Case Officer: Katherine Daniels

Applicant: Great Lakes UK Limited

Proposal: 1. Introduction of ventilation grilles above all guestroom windows;
2. Reduction of brick plinth to back of house areas of waterpark building;
3. Change of rear of hotel from stone to render retaining stone surrounds and sills; 4. Change of rear of hotel from stone to timber with timber surrounds and metal sills; 5. Change from stone plinth to buff brick plinth to back of house areas of waterpark building; 6. Change of buff brick from blue brick material around plinths; 7. Reduction of extent of plant screening above conference zone where plant is no longer present; 8. Reposition slow windows to eaves to raise them slightly; and, 9. Re-align windows above porte cochere (proposed as non-material amendment to 21/04158/F)

Proposed Elevations - East

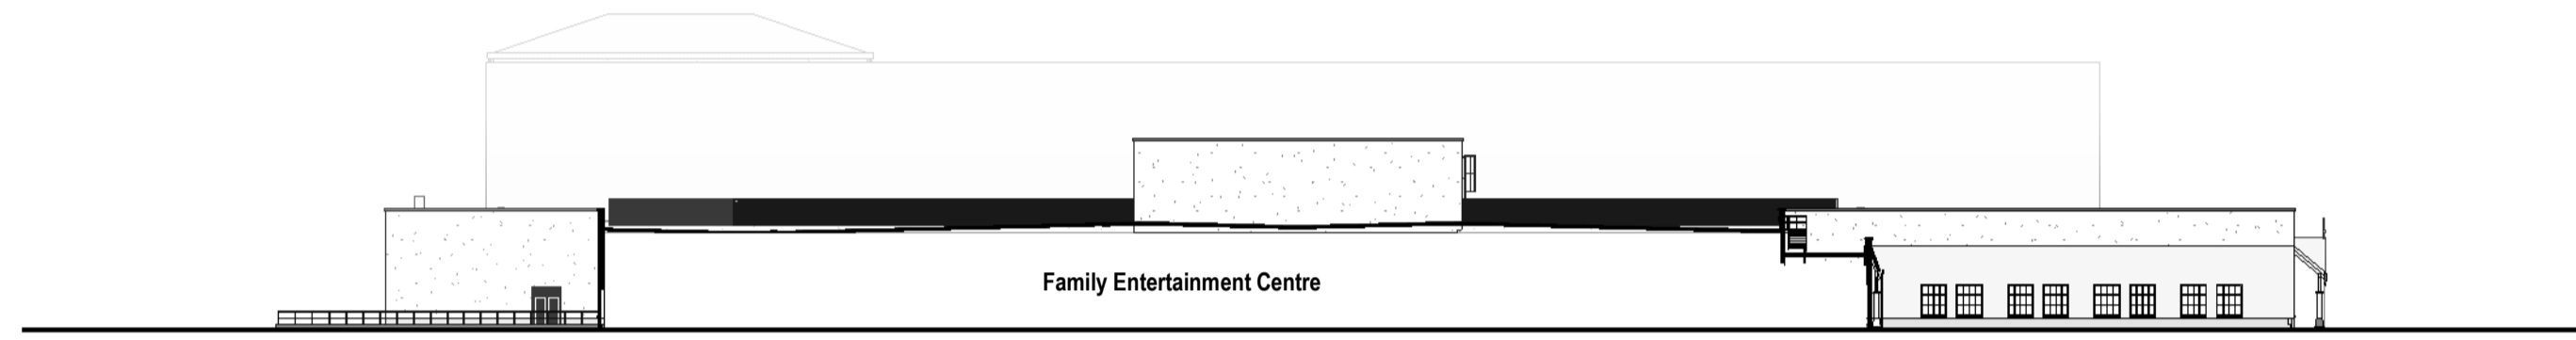
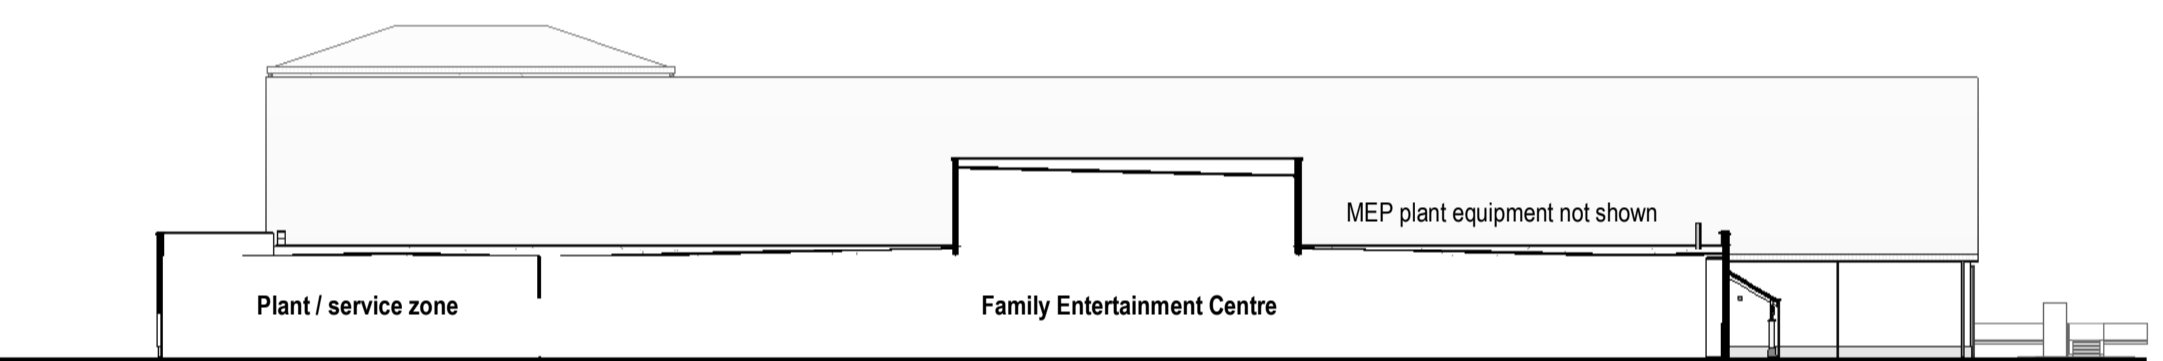
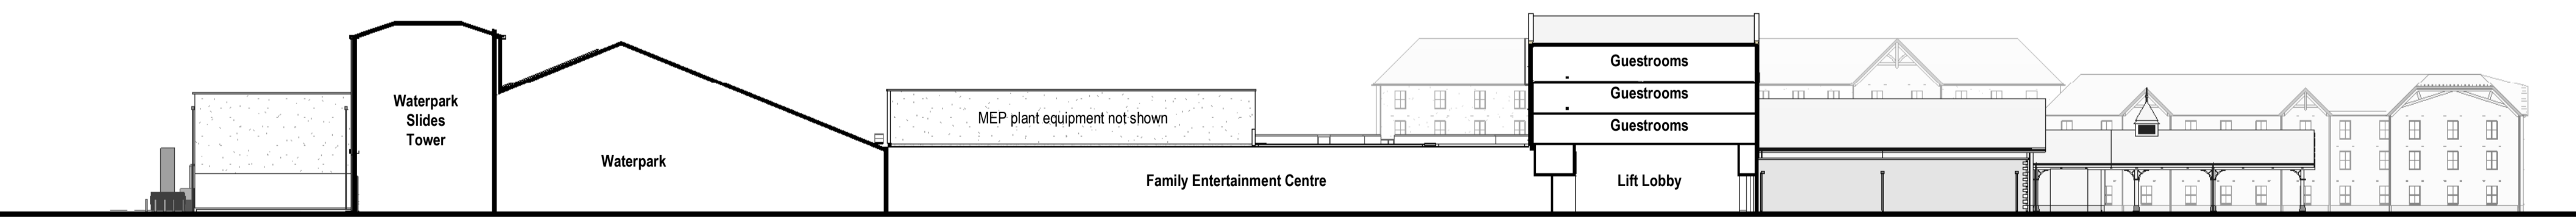
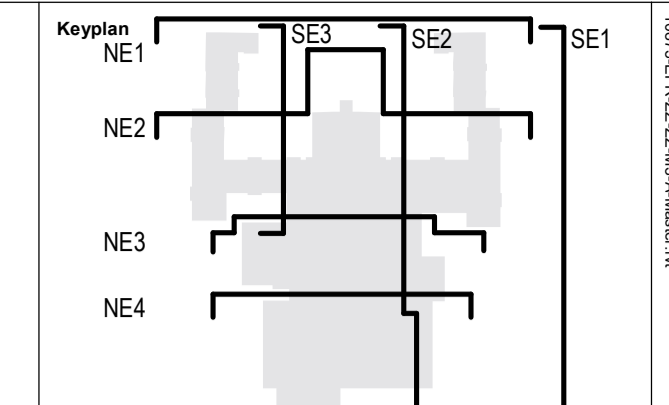
- 5.5. The introduction of ventilation grilles above the guestrooms is a change to the overall appearance of the building, however given the size of these grilles and the massing of the proposed building, it is unlikely to result in a material change to the overall character of the building. The character of the building will still remain.

- 5.7. Changing the rear of the hotel building to render from stone, again is an unfortunate change, however the overall style of the building will remain. Limited views would also be had to this part of the building; therefore the change again is not material in the overall scale of the building. The massing will still be similar, and the building will still have a different material, which will still break the overall massing up.

- 5.8. The proposal also seeks to change the rear of the hotel from stone to timber. This is similar to the stone to render. It is unfortunate, however the overall design and appearance will still remain as a result of the proposed changes.

- 5.9. The changes to buff bricks from blue brick material around the plinths, is not considered to be significant. In addition, the material condition can ensure the
